Subject: Planning application N6/2010/2044/FP - 45 Howardsgate

Response to Planning application from Hertfordshire County Council (T and CP GDP Order 1995)

Installation of one internally illuminated fascia and one internally illuminated projecting sign

FRONT ELEVATION

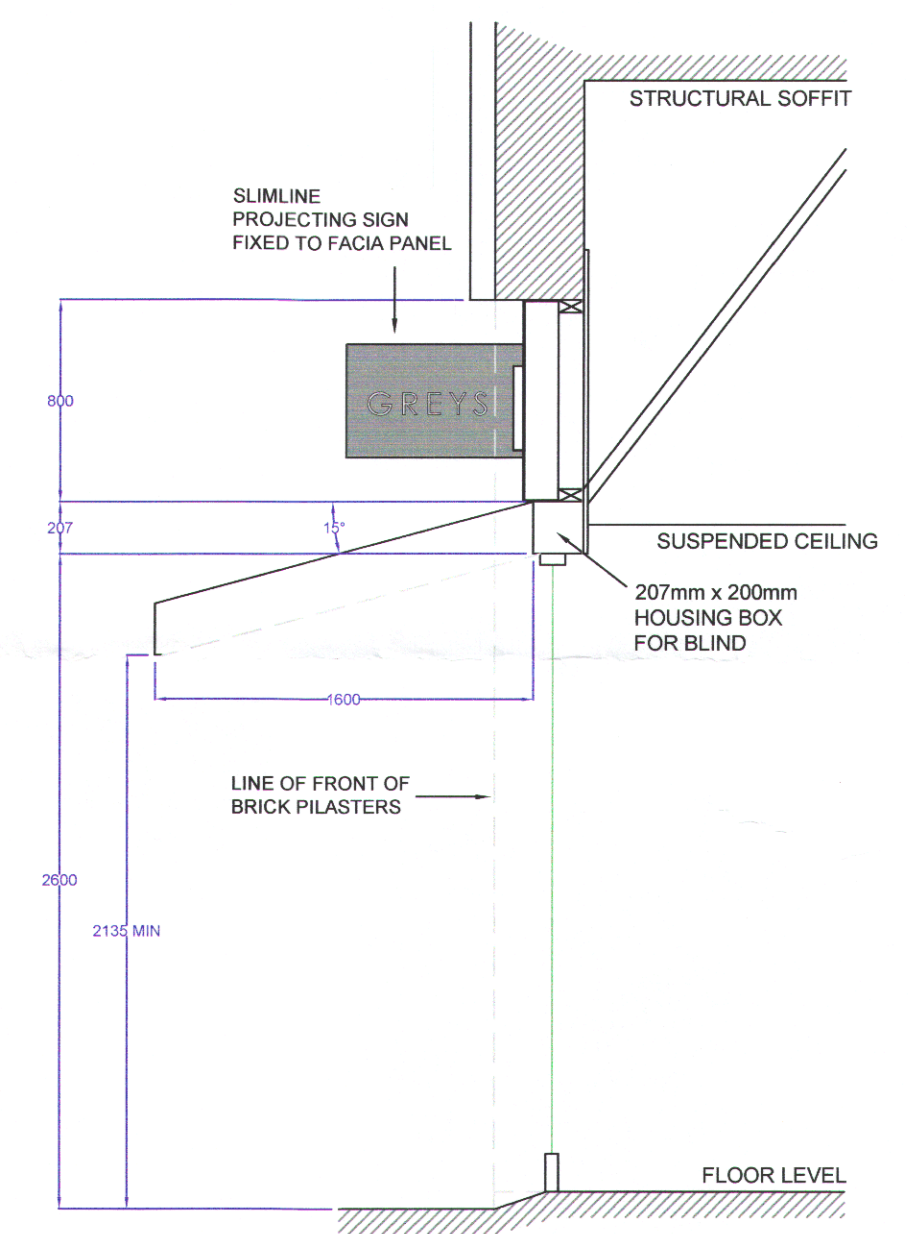
1. The intensity of illumination shall be controlled at a level that is within the limit recommended by the Institution of Lighting Engineers in the publication "Brightness of illuminated Advertisements" ILE Technical Report No 5.

2. All parts of the projecting signage must be at a height of, or greater than 2.1 m vertically above the footpath and no less than 500 mm horizontally from the edge of the carriageway. Reason: In the interests of pedestrian/highway safety and convenience.
